Rezoning Transportation Analysis

Petition Number: 2023-169

Date	Description
01-24-24	First Review (ME)

REZONING PLAN
RZ.01

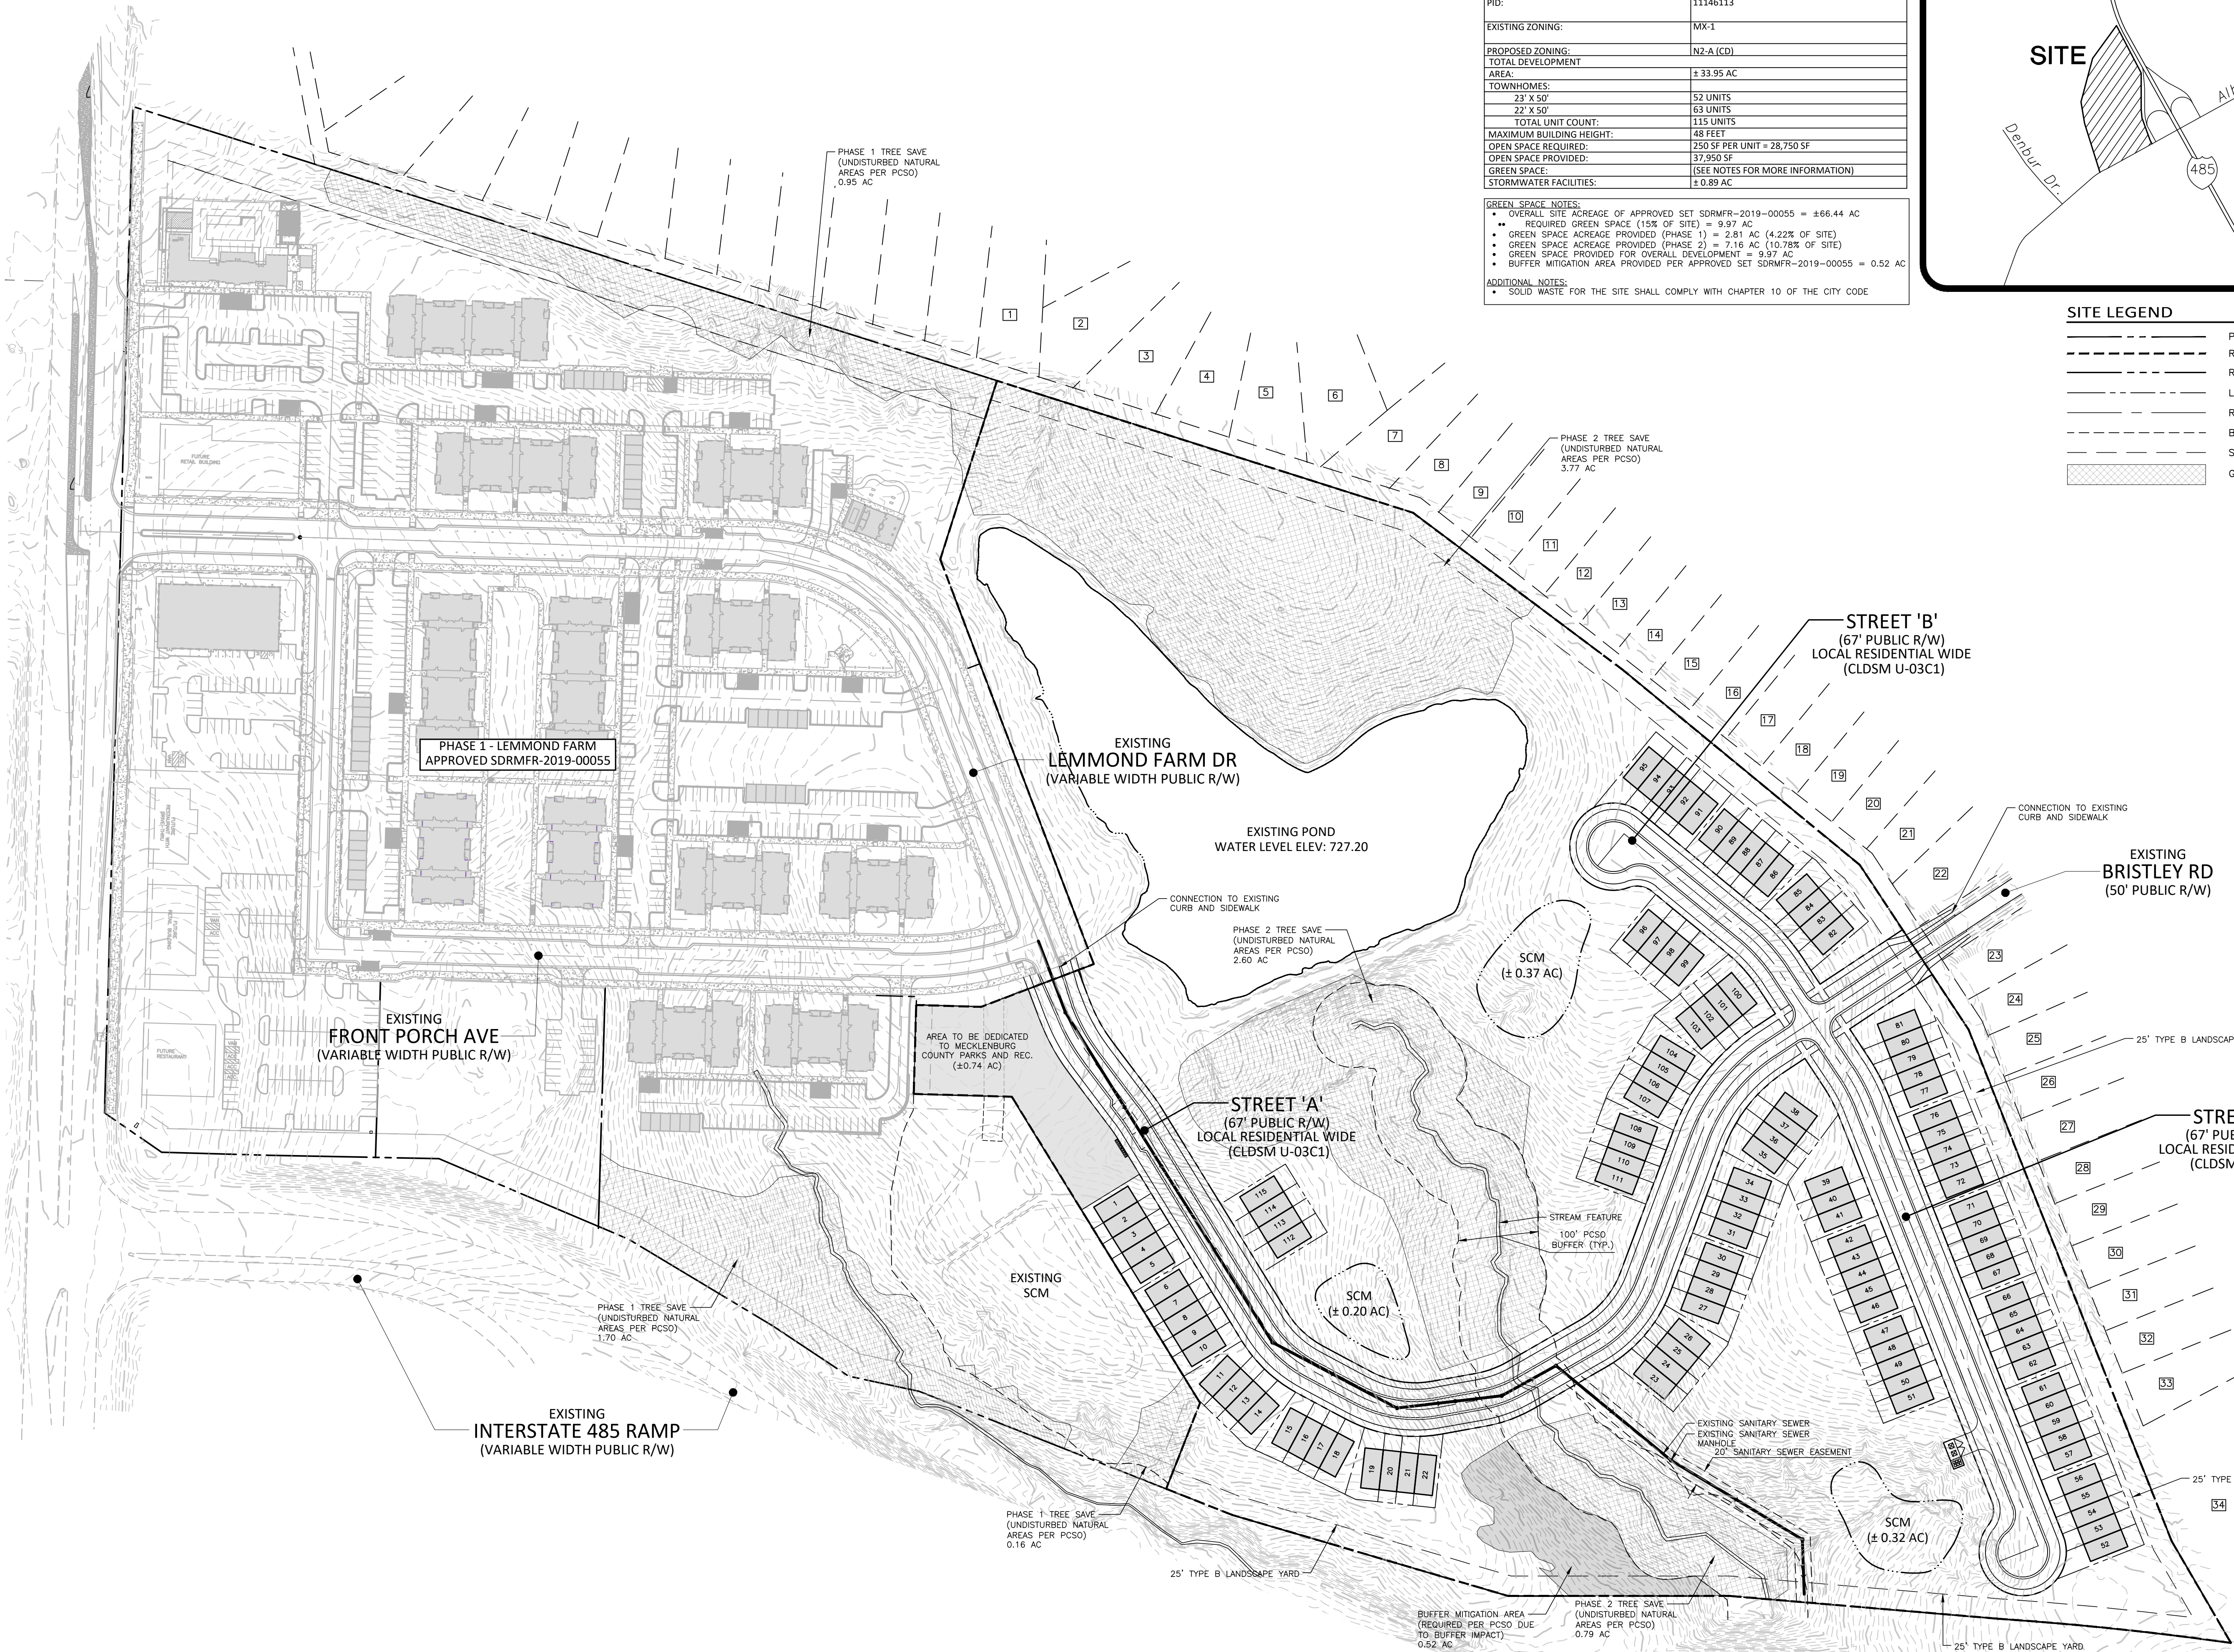
- a. **Street A:** Location of curb and gutter to be installed to 17.5 feet from roadway centerline to accommodate the CLDSM Detail U-03.
- b. **Street B:** Location of curb and gutter to be installed to 17.5 feet from roadway centerline to accommodate the CLDSM Detail U-03.

Label and dimension the curb and gutter from the centerline for each road on the site plan.

3. Revise site plan and conditional note(s) to commit to dedicate 25.5 ft right-of-way from the road centerline for Street A and Street B. The site plan shall label and dimension the right-of-way from the road centerline.
4. Add a conditional note specifying "A Right-of-Way Encroachment Agreement is required for the installation of any non-standard item(s) (irrigation systems, decorative concrete pavement, brick pavers, etc.) within a proposed/existing City-maintained street right-of-way by a private individual, group, business, or homeowner's/business association. An encroachment agreement must be

5. Revise site plan and conditional note(s) to commit to construct an 8-foot planting strip, and 8 foot sidewalk on Street A per CLDSM U-03. The site plan shall label and dimension both items from the back of curb and gutter or edge of pavement.

6. Revise site plan and conditional note(s) to commit to construct an 8-foot planting strip, and 8 foot sidewalk on Street B per CLDSM U-03. The site plan shall label and dimension both items from the back of curb and gutter or edge of pavement.

7. Revise site plan and conditional note(s) to commit to alley loaded driveways on Street A where possible.
8. Add a conditional note specifying “the Petitioner shall dedicate and convey in fee simple all rights-of-way to the City before the site’s first building certificate of occupancy is issued. CDOT requests rights-of-way set at 2’ behind back of sidewalk where feasible.”

11. Revise site plan and conditional note(s) to construct 8-foot planting strips and 8-foot sidewalks on Street A and Street B. The site plan shall label and dimension both items from the back of curb and gutter or edge of pavement. Add conditional note The entire facility must be outside of the right of way and within a public access easement. Add conditional note committing to construction and maintenance of the 8-foot sidewalks on Street A and Street B.
